Application Reference: P/107/25/DOC Site Name: Land West of Hook Lane Pagham PO21 3PB	Initial Issue Date: 31/10/25 Issue Date: 31/10/25 Reviewer Reference: ADC/EXT4
--	--

Condition 9: **Objection**

ADC Drainage Comments (P/29/25/DOC)	Designer Response	ADC Drainage Comments	Designer Response	
Date:	12/07/2024	18/07/2024	30/10/2025	12/11/2025	
Condition Number: 9 Surface Water Drainage

ST1
(CLOSEST LOCATION TO TREES)
SCALE 1:20

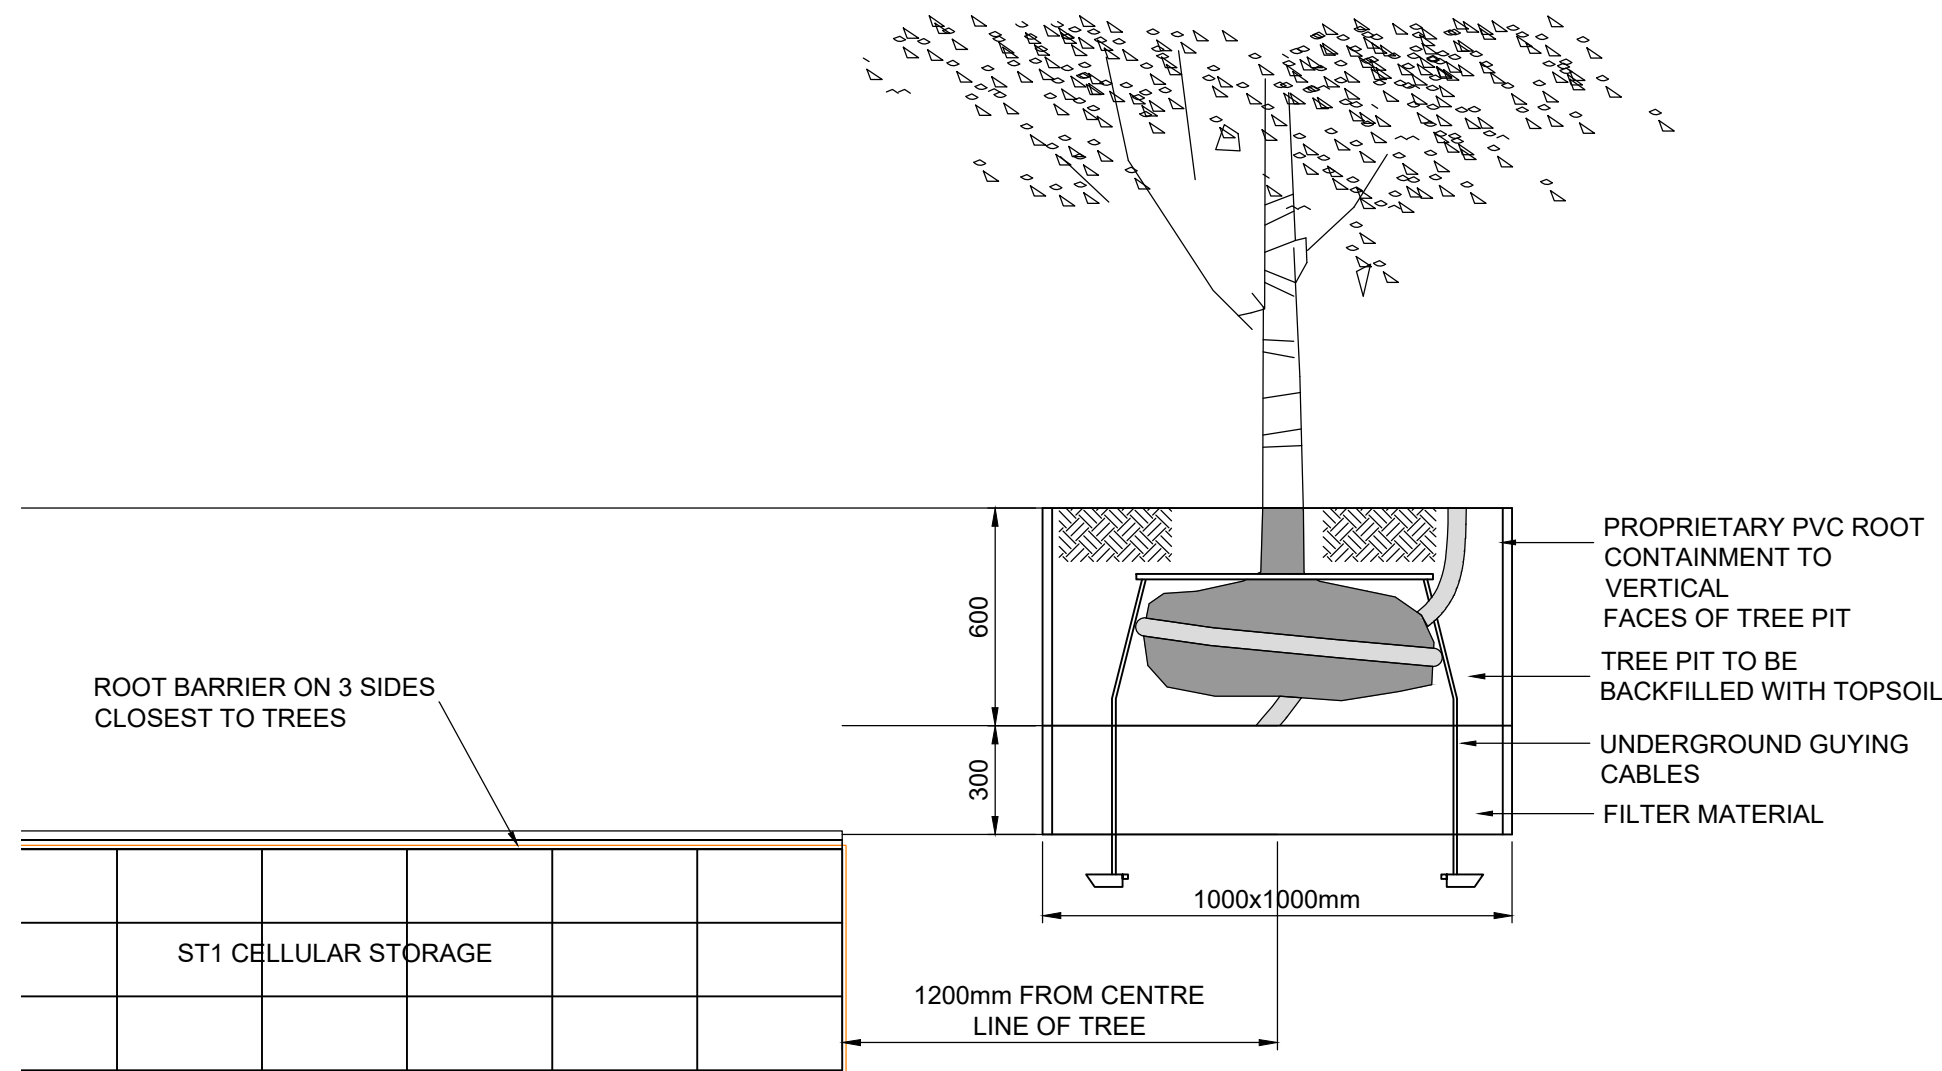
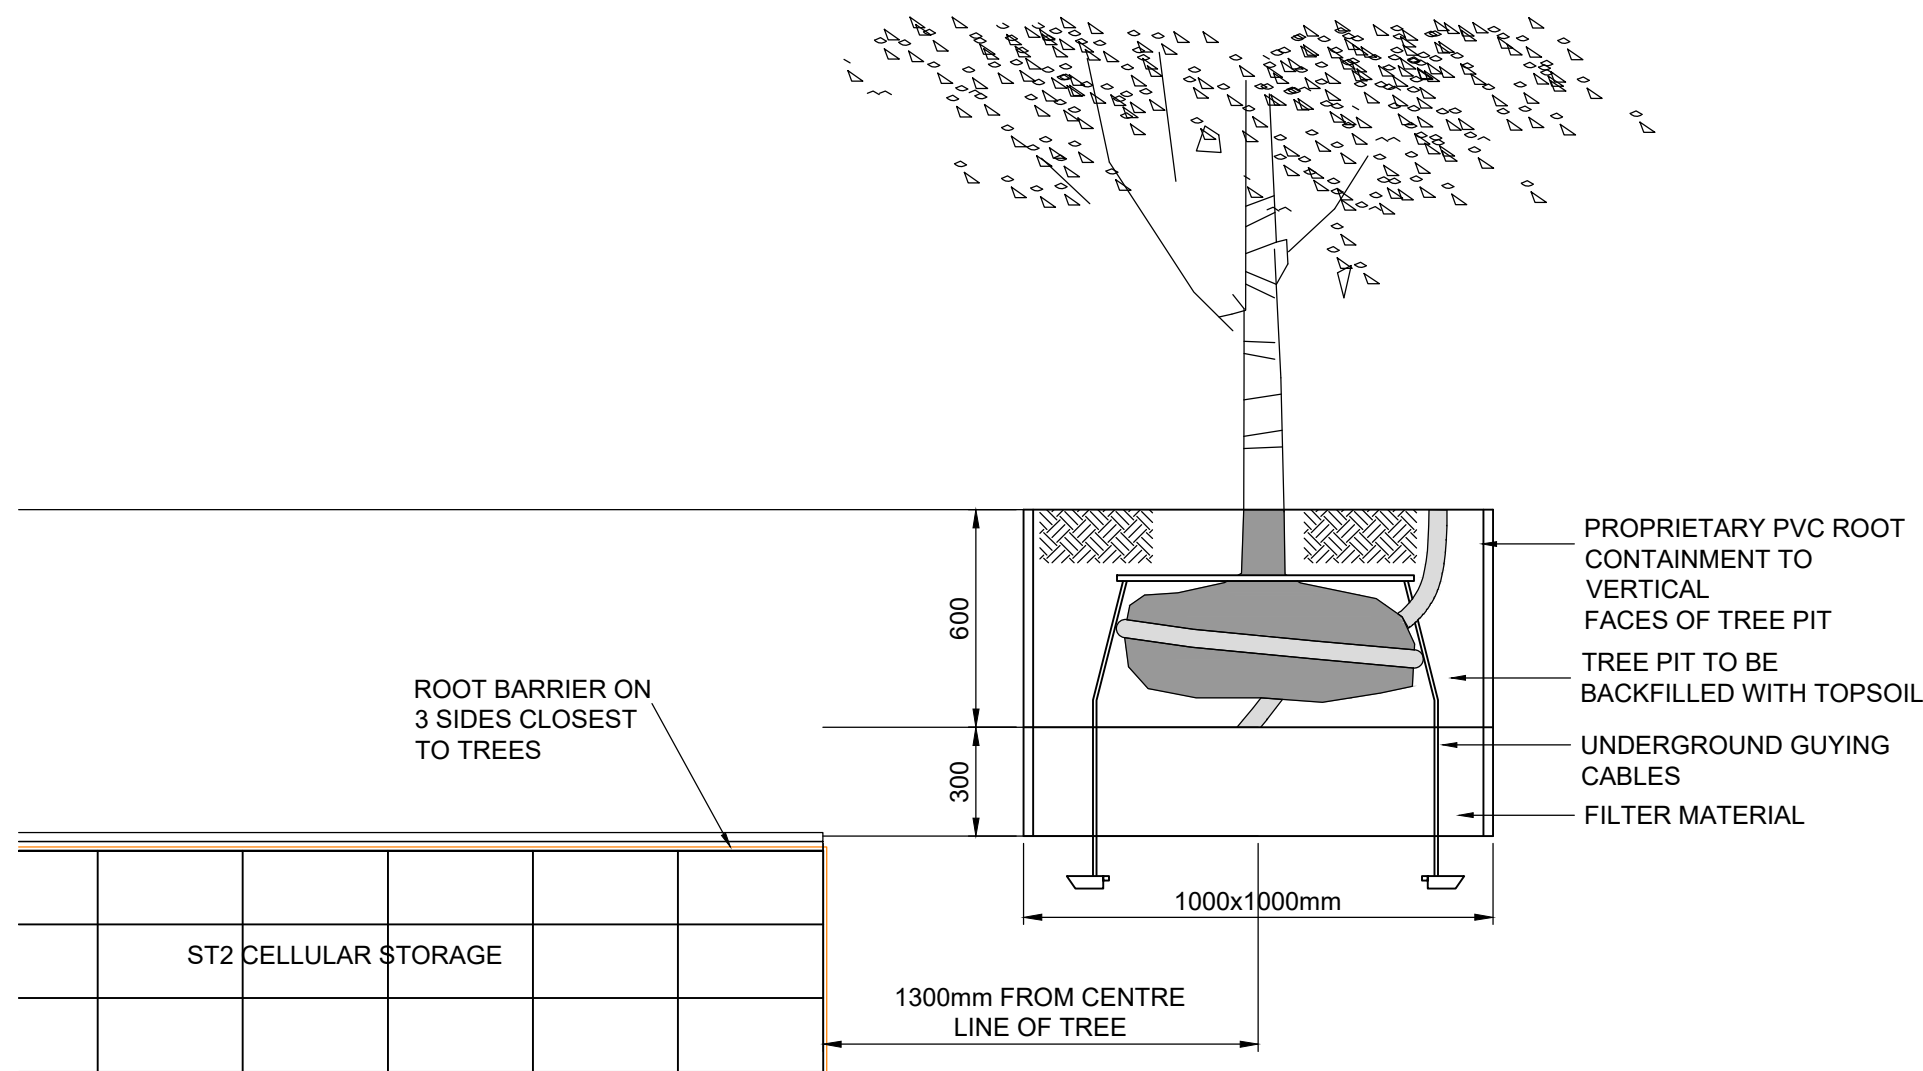
a) The indicative landscape proposal drawing shows a tree very close to tank ST1. Section A-A provided does not appear to represent this.  b) Provide information from the root barrier manufacturer and the tank manufacturer that the proposal is acceptable. c) Demonstrate that the tanks are structurally sufficient given the close proximity of the trees. d) Provide accurate cross sections showing that there is adequate space for the building foundations, foul and surface water drainage pipes, tree pits e) Demonstrate that the roots of the trees planted close to the permeable	A. Rev C Calculations - Updated Drawings & Calculations. B. See Appendix G. C. See Appendix G. D. Updated Drawings & Calculations. E. See Appendix G.	f. item now closed g. (New Item) there appears to be clashes on the proposed drainage runs and trees SW-IC03.01 to SW-MH-02.01 and SWIC-01.03 to SW-IC01.04	See revised drawings in Appendix F showing no clashes with trees.
